Address: Nos. 134 – 144 Pitt Street, Redfern
Proposal: Mixed Use Development
OCTOBER 2017

RESPONSE TO SUBMISSIONS

RESPONSE TO SUBMISSIONS
FORMER RACHEL FORSTER HOSPITAL
NOS. 134 – 144 PITT STREET, REDFERN

PREPARED FOR KAYMET CORPORATION PTY LTD

**LEGEND**

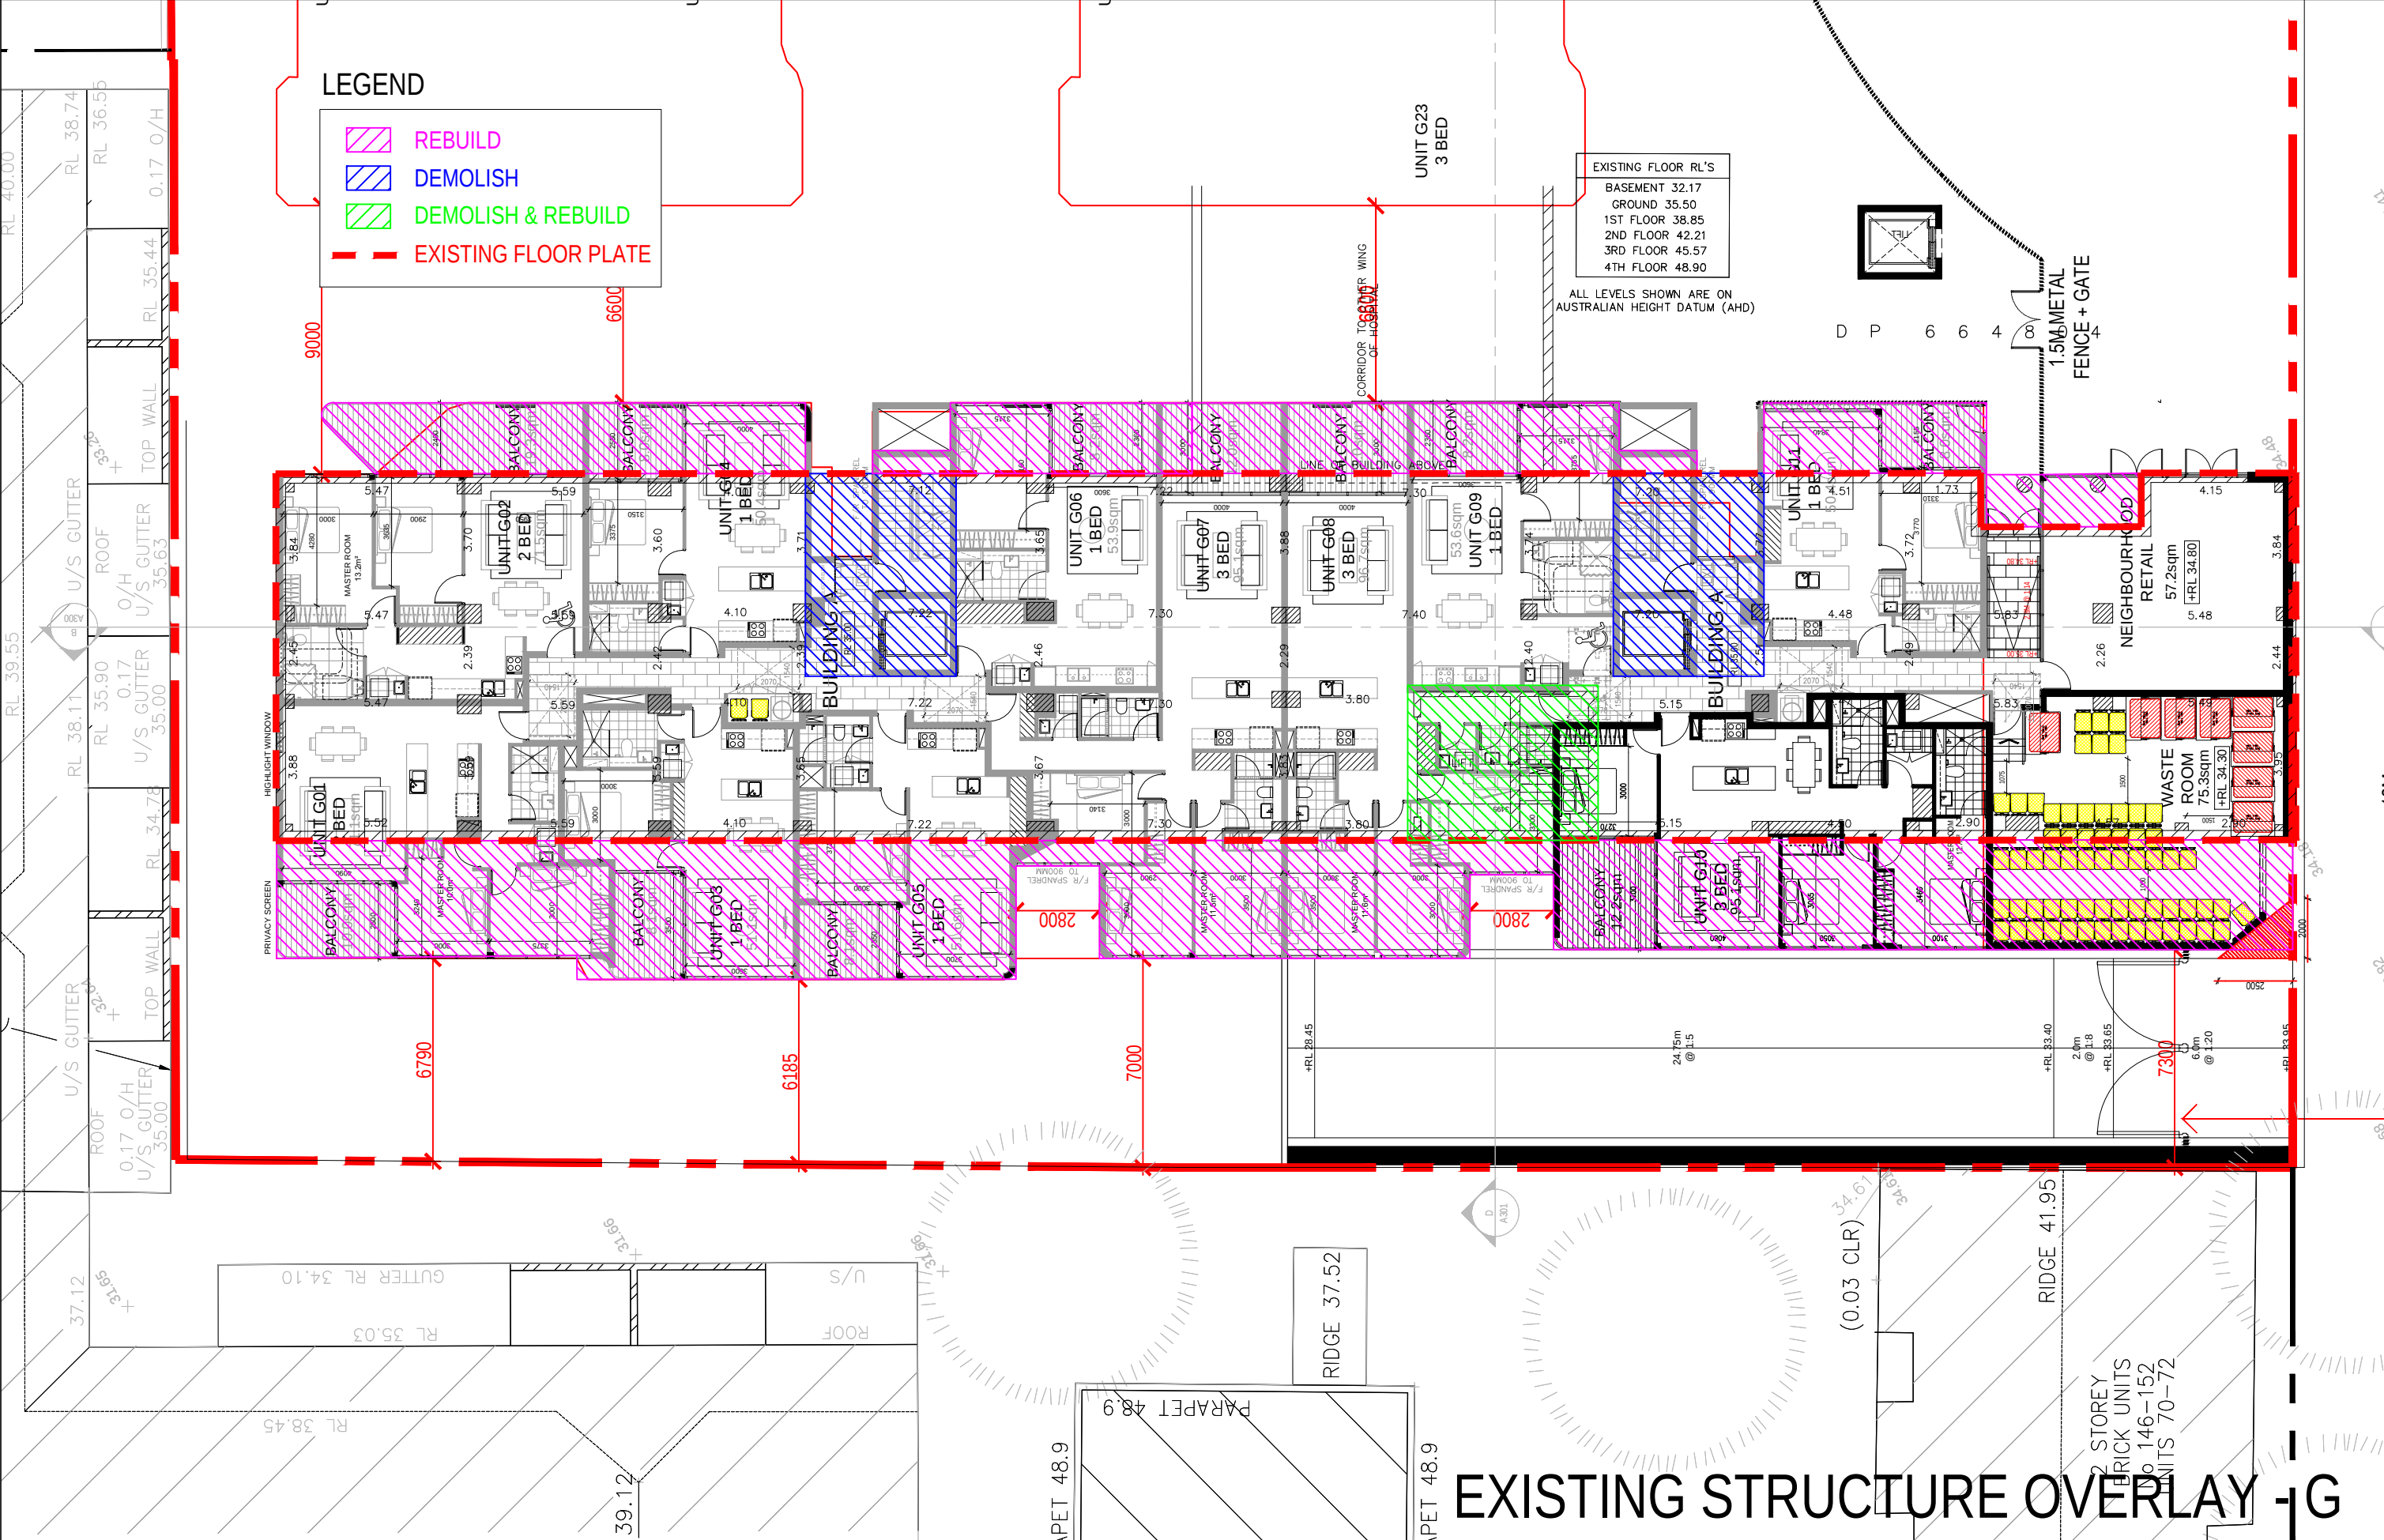
- 8) *Please clarify the proposed extent of demolition of Building A, as the proposed demolition plan is ambiguous in respect of the proposed demolition.*

Comment: See Drawing Nos. A350 – 358 at **Attachment II** and Structural Report at **Attachment VIII**.

WAYFINDING DIAGRAM

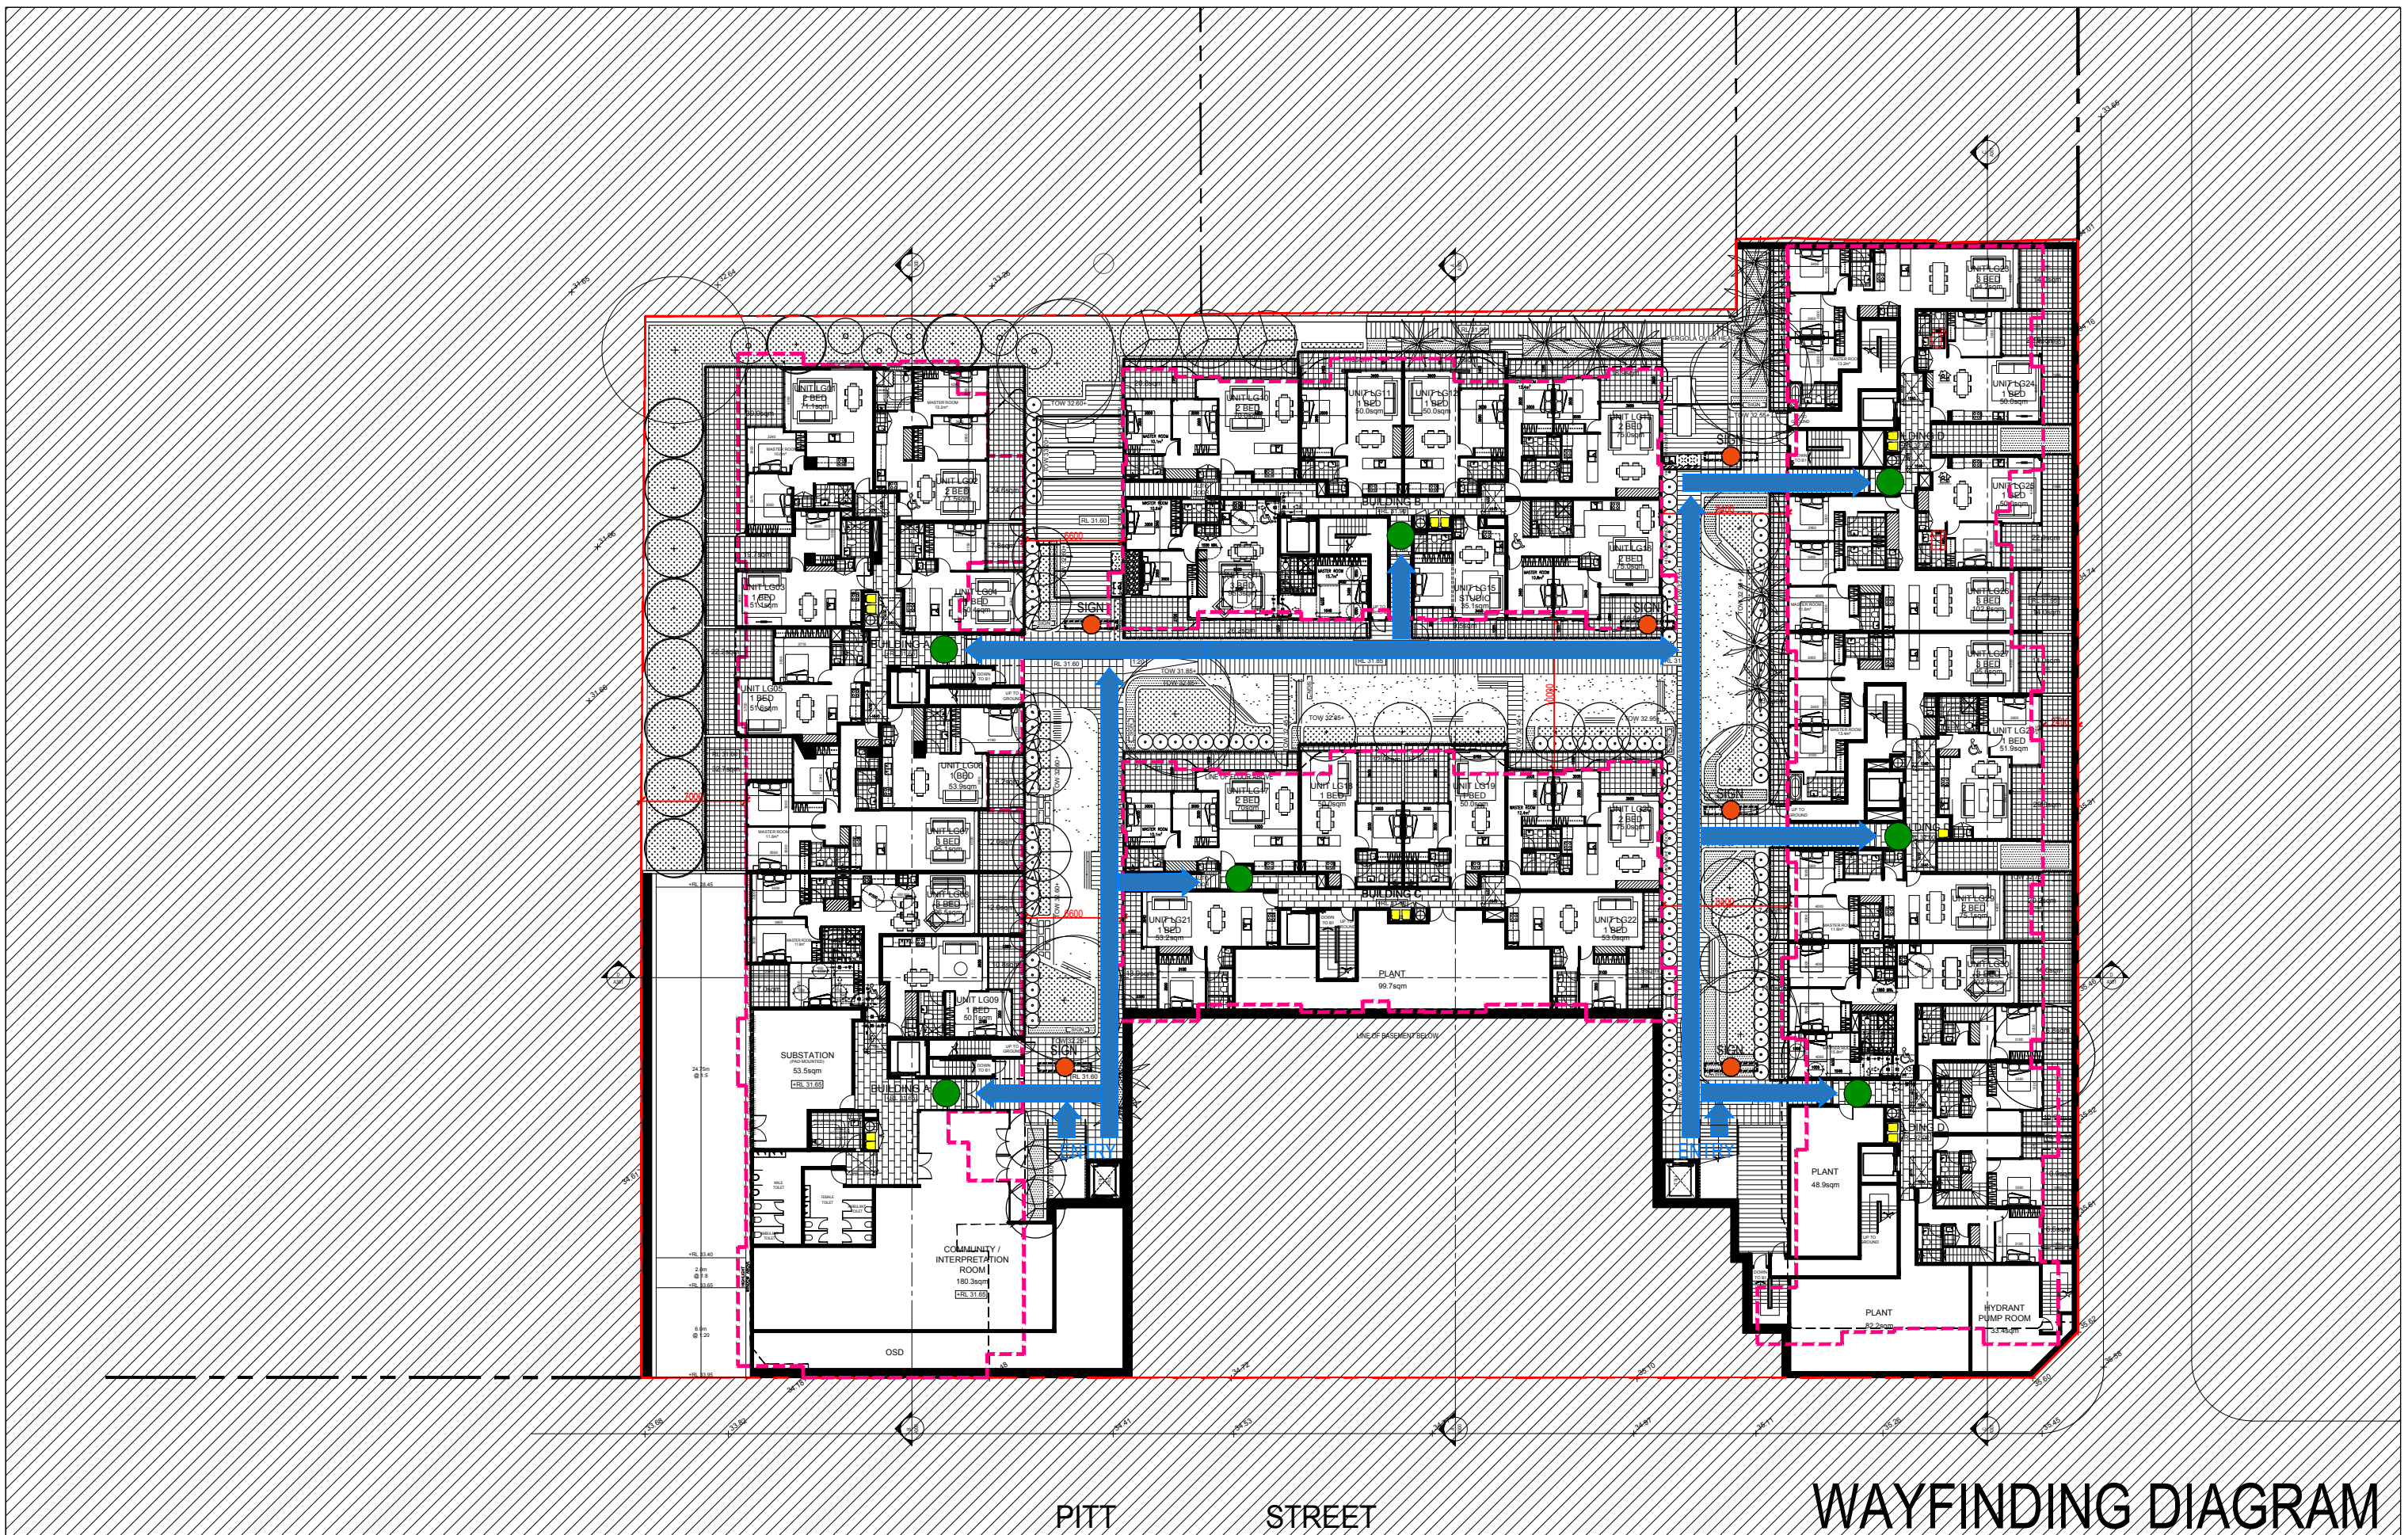
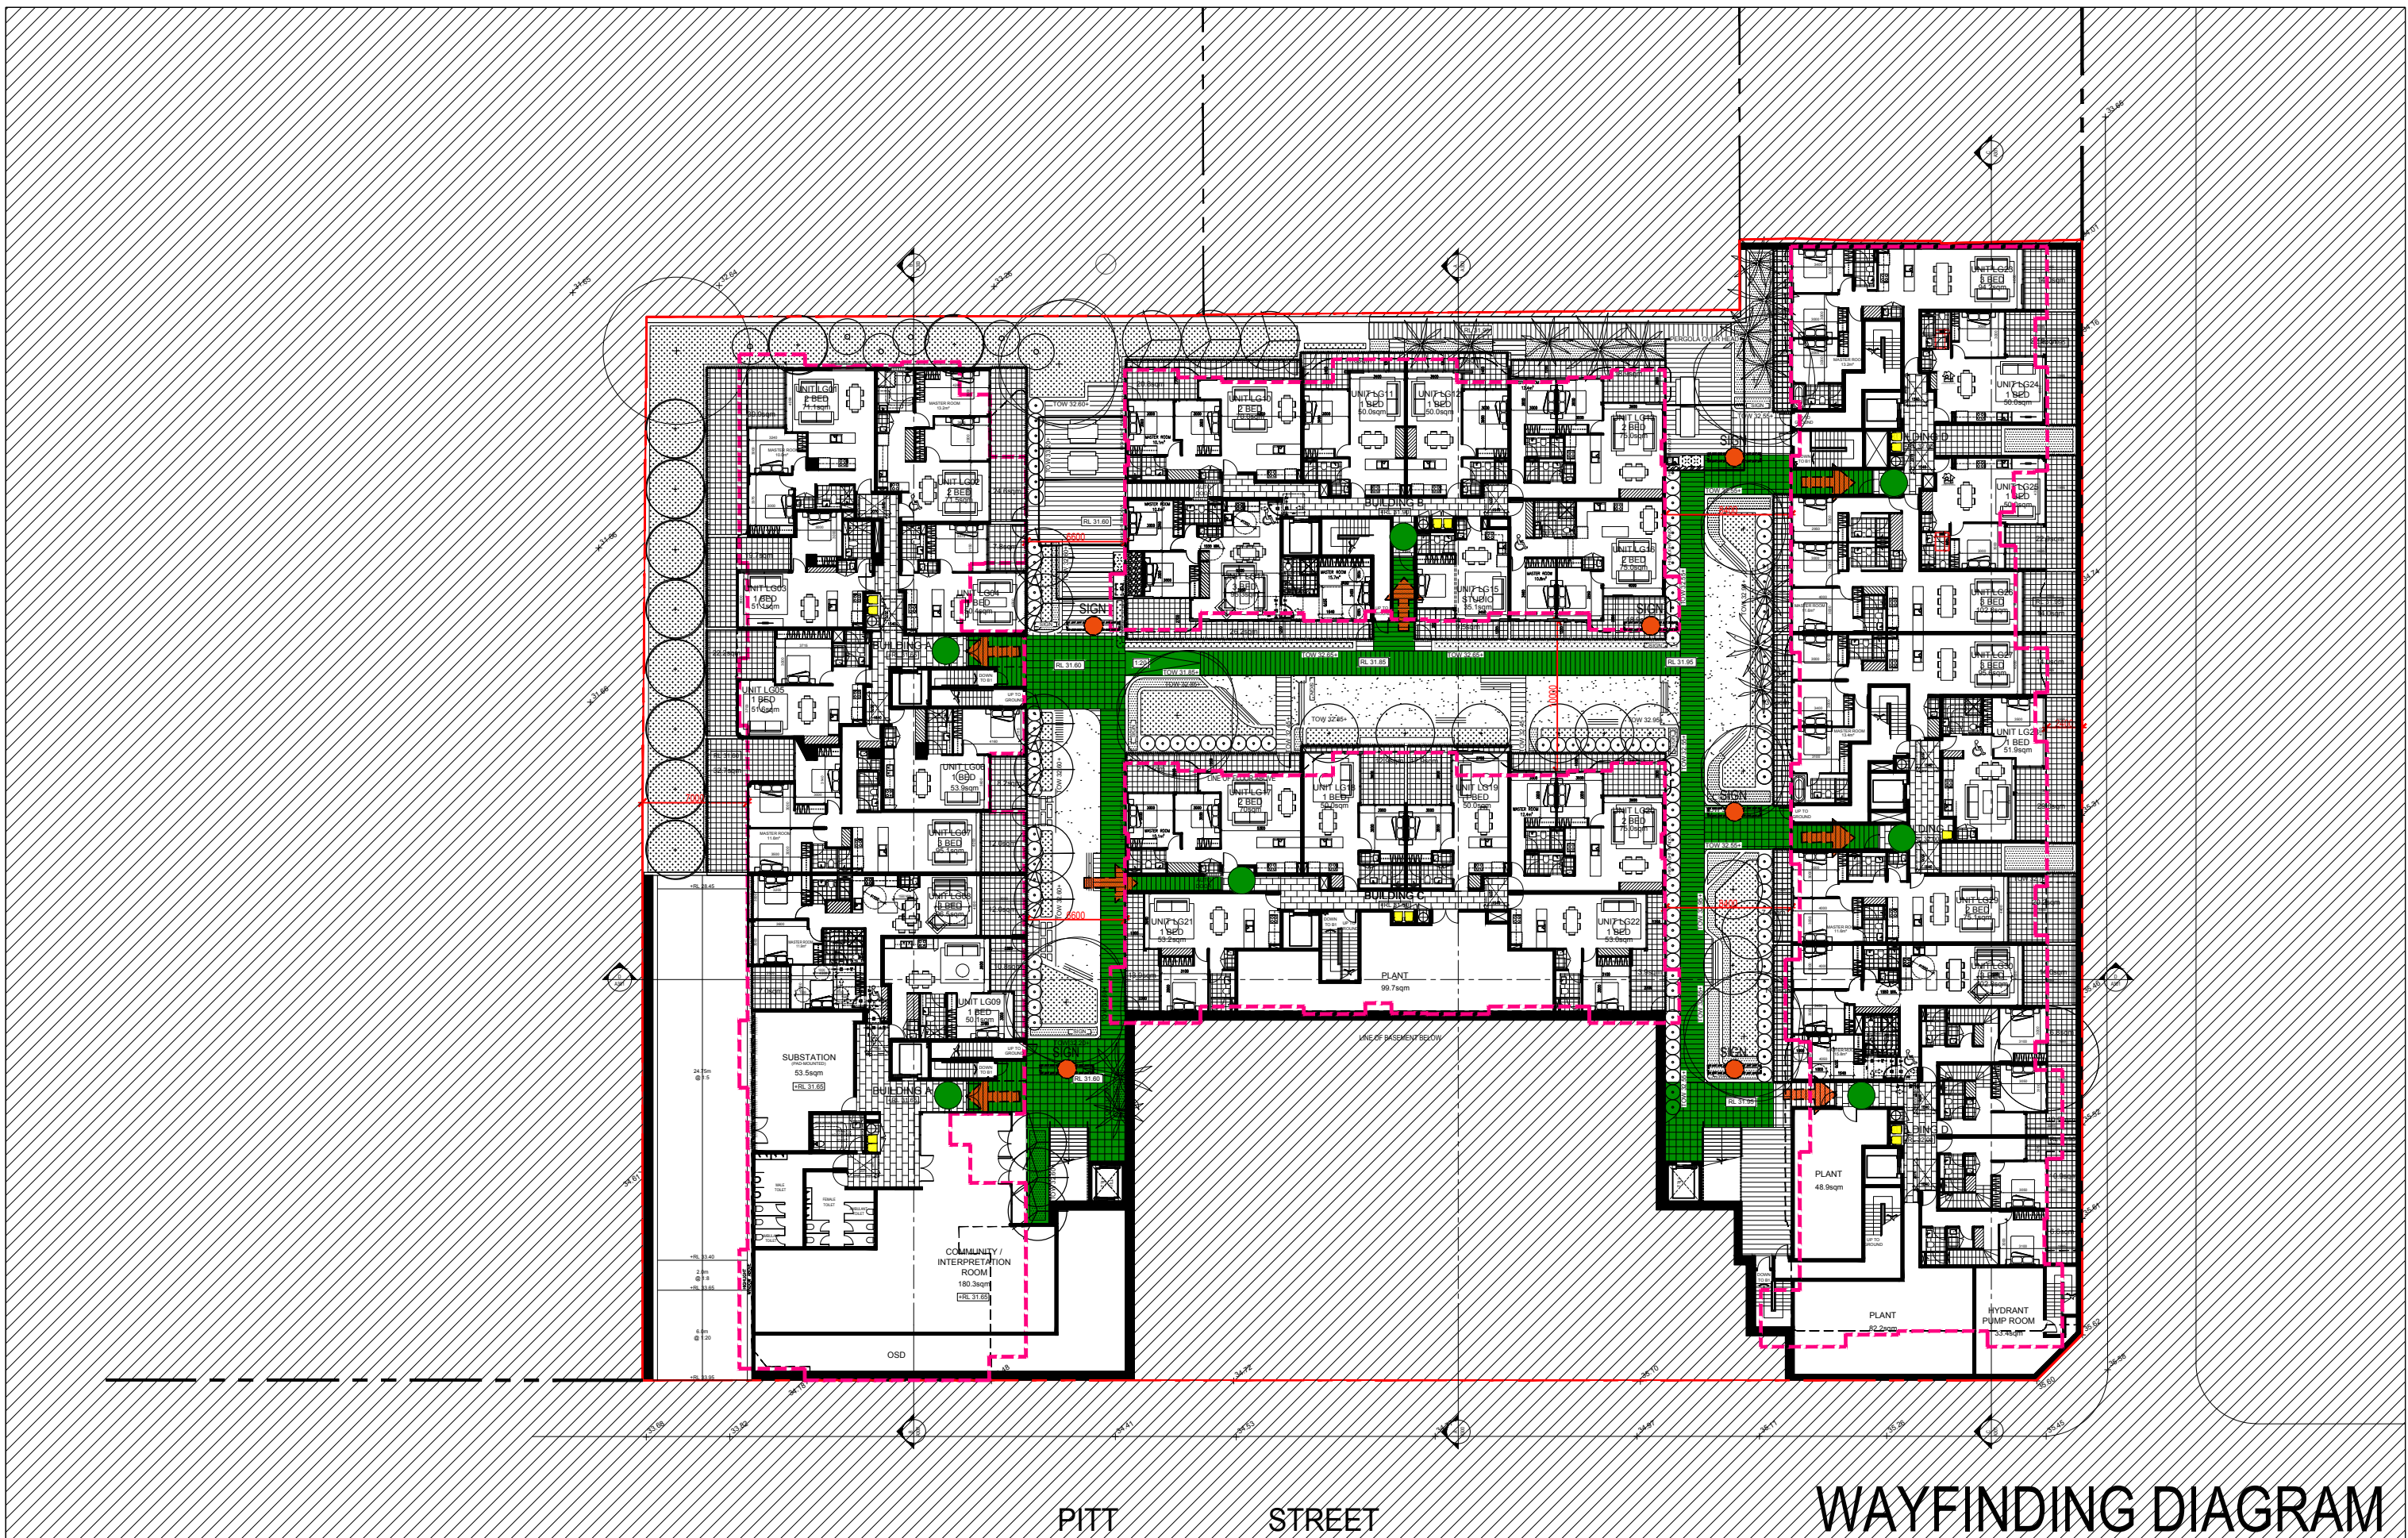
- 5) *Further clarification should be provided for wayfinding across the site, in order to clearly delineate the residential component of the site from the publicly accessible open space, and to clearly identify entries to the residential component.*

Comment: The removal of 'retail premises' from the site, limiting neighbourhood shops to the interface with Pitt Street only, promotes a much clearer delineation between private and publically accessible areas of the site. Additional wayfinding diagrams have been prepared by Tony Owen Partners (see Revised Architectural Drawings at **Attachment II**).
